CITY OF ALBUQUERQUE

August 22, 2013

**Re: Gallinger Studio/Apartments
Lots 8 & 9, Block 1, New Year Addition, 616 Washington St. NE
Grading and Drainage Plan
Engineer's Stamp Date 7-02-13 (J17/D033)**

## GRADING & DRAINAGE PLAN

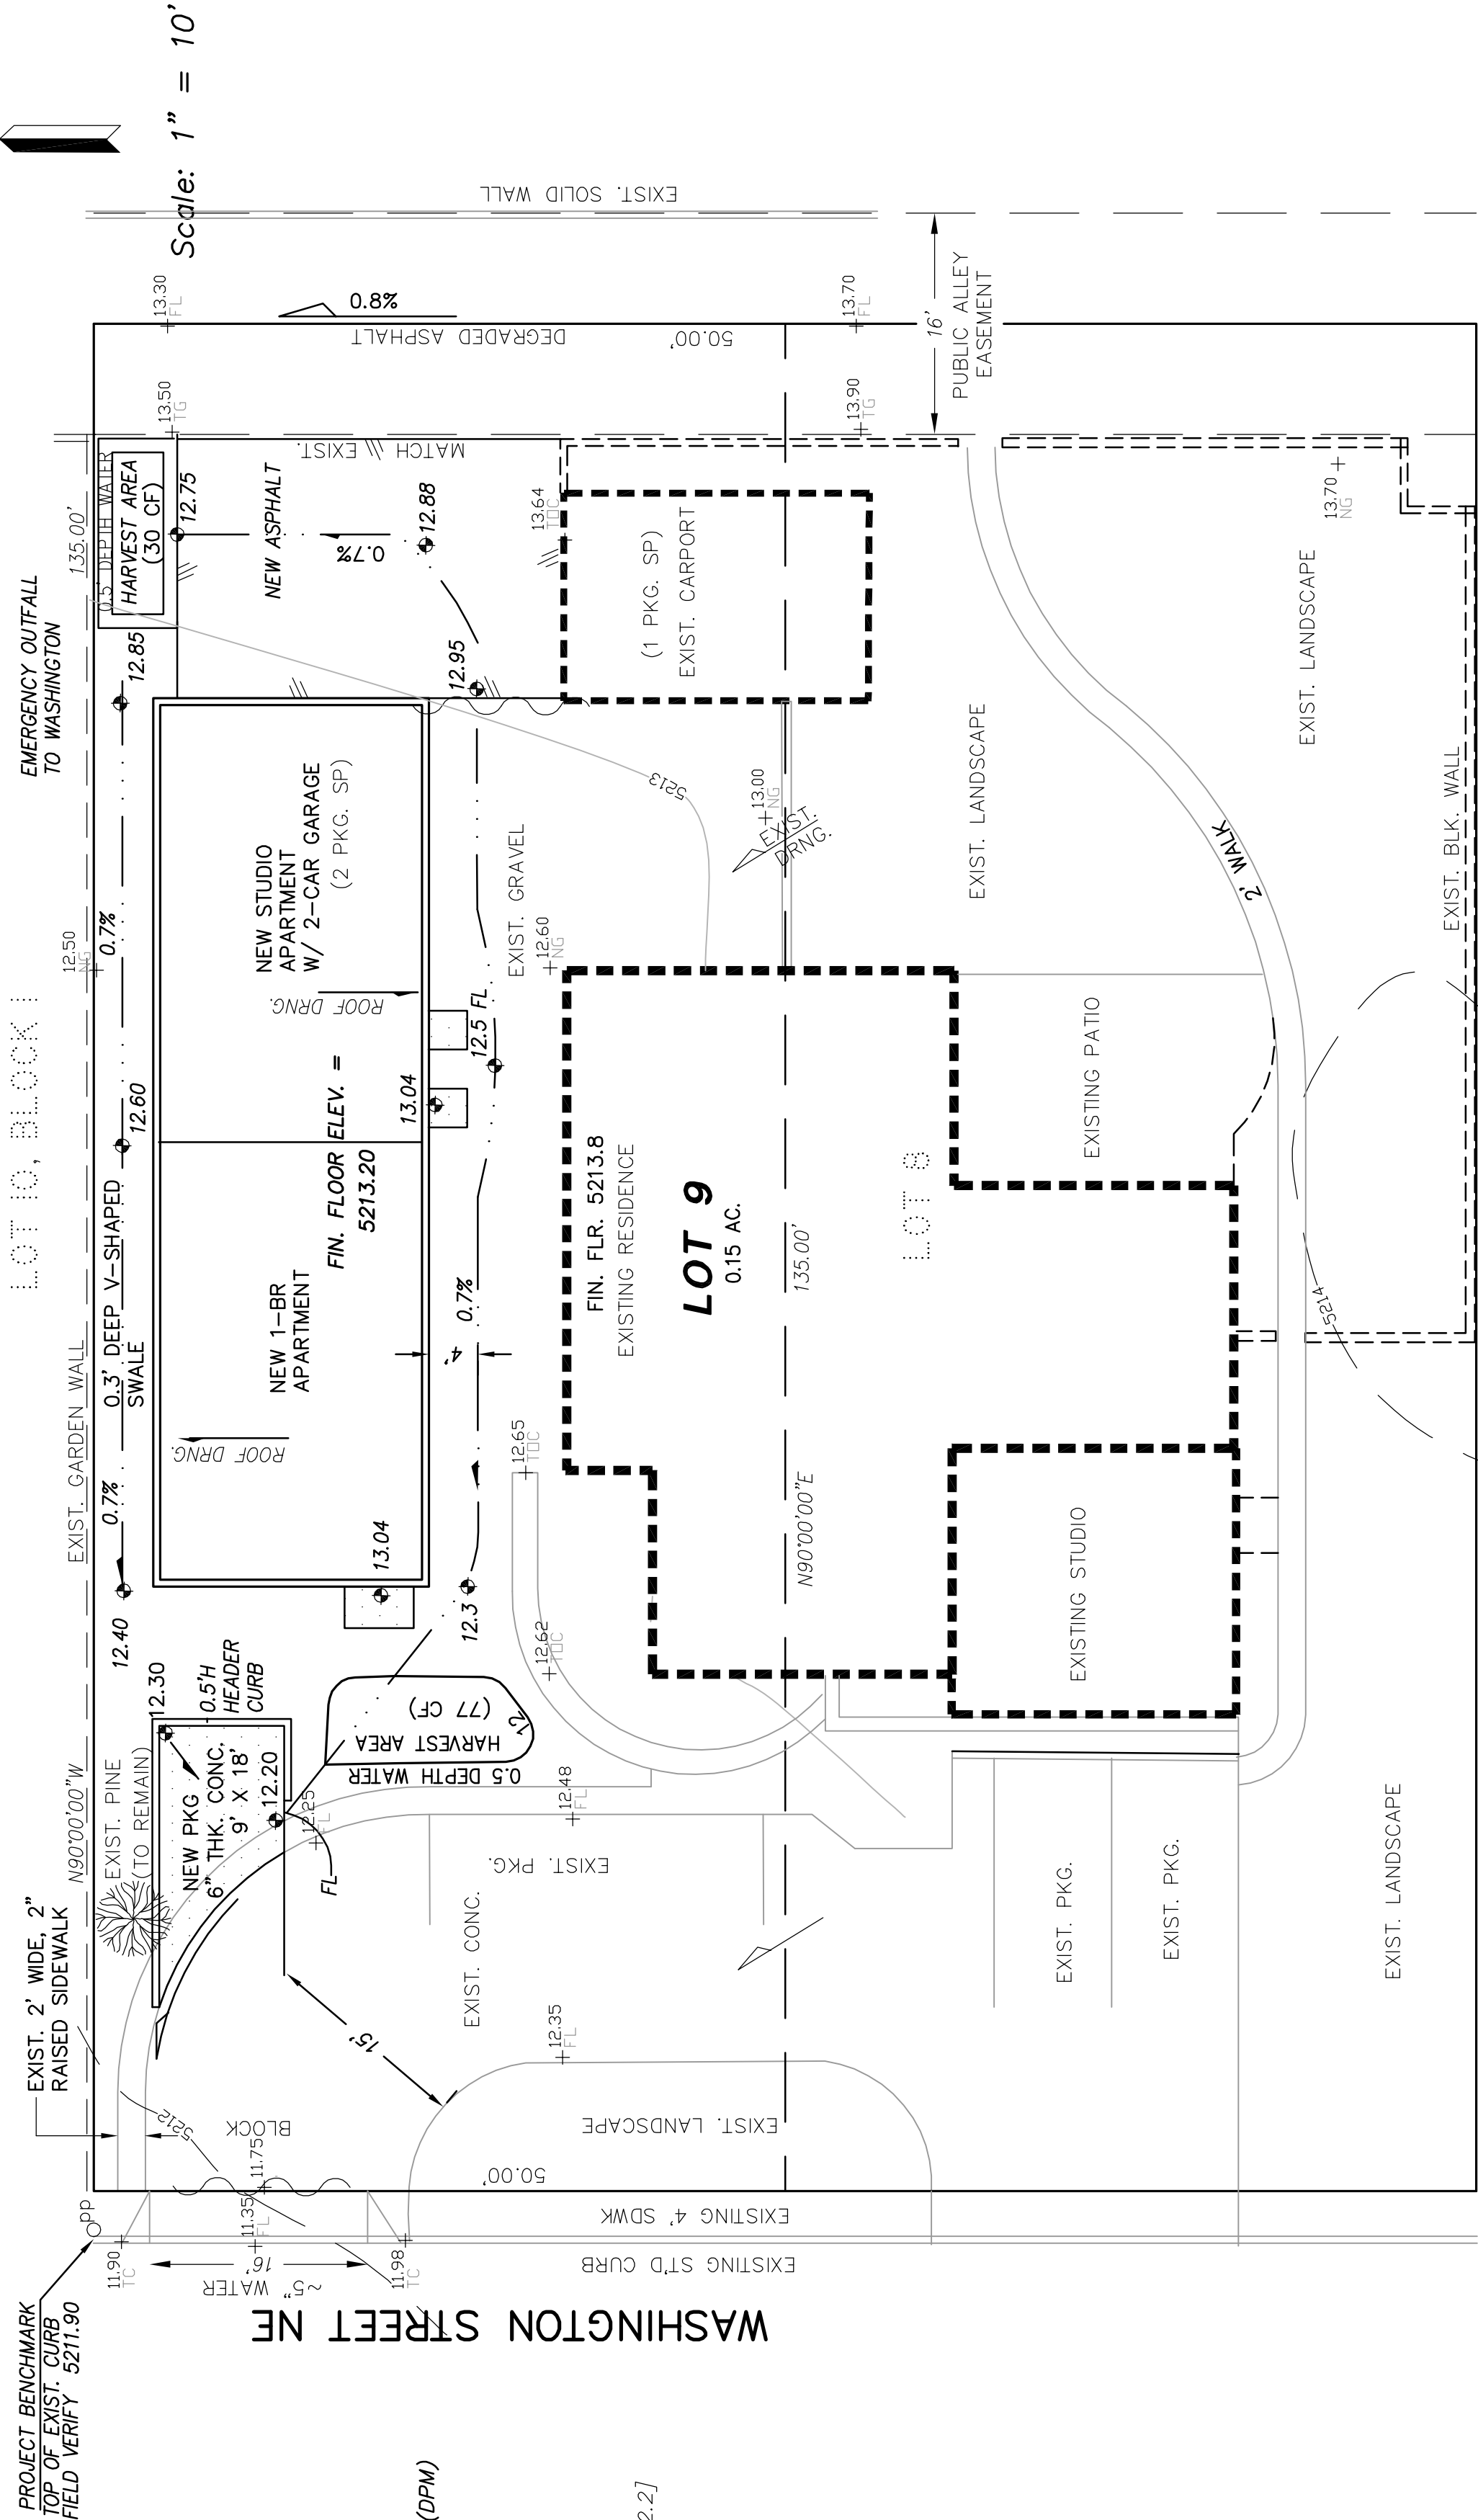
- Change the title of the project to Galligner Studio... and Legal Description to Lots 8 & 9, Block 1, New
- How does Lot 8 drain? Does it enter Lot 9? Show roof flow directions for all the buildings.
- Show all the proposed and existing parking spaces. Is there any Handicap parking? Does it meet ADA?
- Show the doors and landings with spot elevations for the new and existing buildings.
- Show detail elevations along the alley to assure proper drainage.
- Provide additional elevations throughout the property around the buildings, along the property line and flow line in the street. Is there a water block at the entrances from Washington Street.
- At the NE corner of the project a wall is shown in the alley.
- Is there a swale proposed on the north side of the proposed buildings? Provide Detail.
